LU/234/21/L

13 South Terrace Littlehampton BN17 5NZ

Listed building consent to re-paint front elevation where already previously painted (Paint colour is pale grey 'Shallows' by Little Greene Paint Company), replace 2 No. PVCu windows on top floor at front of house with timber framed casement windows with slimline double glazed glass & replace a modern push-bar fire exit door on first floor with a wooden exterior Georgian style door with secure locking system

Proposed Elevation

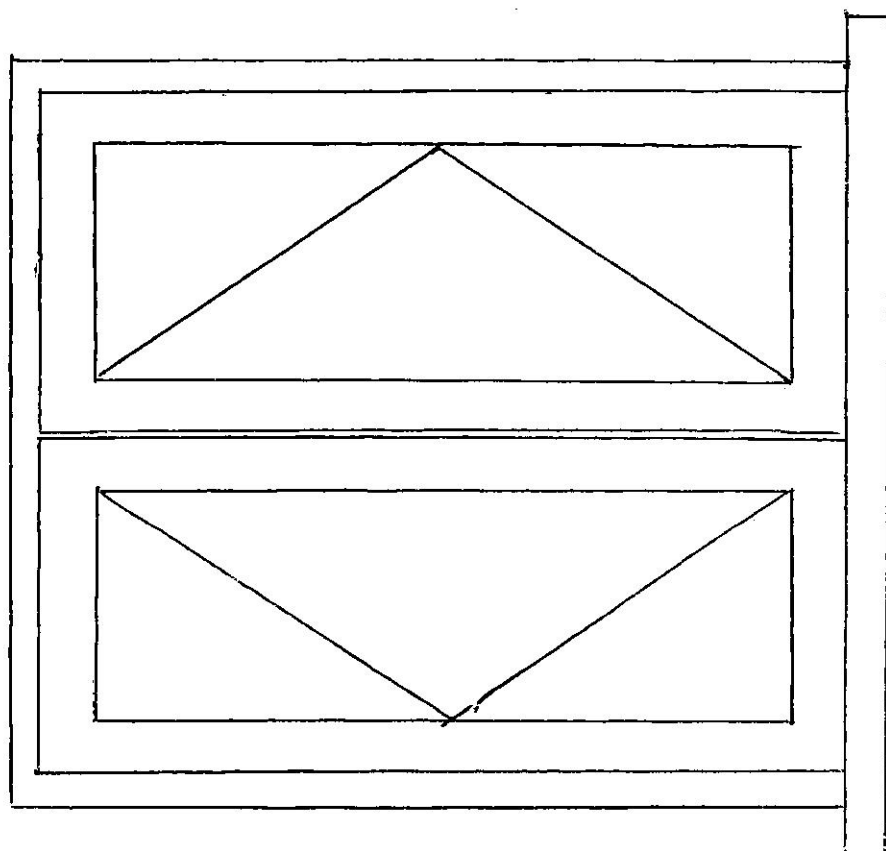
The existing windows on the top floor of the house are of an inappropriate material and their replacement is supported. I note the desire to replicate the existing method of opening and, based on their discrete location, I am happy for the style to remain (in this particular instance). The existing windows being of inappropriate materials and already double-glazed means that I am able to support the use of the slimline double glazing systems. This is on the basis that no historic fabric was affected and that the applicants are attempting to improve the windows at this level. This approach is supported by guidance prepared by Historic England. I hope that the windows will be painted white like the existing ones. You may wish to confirm this.
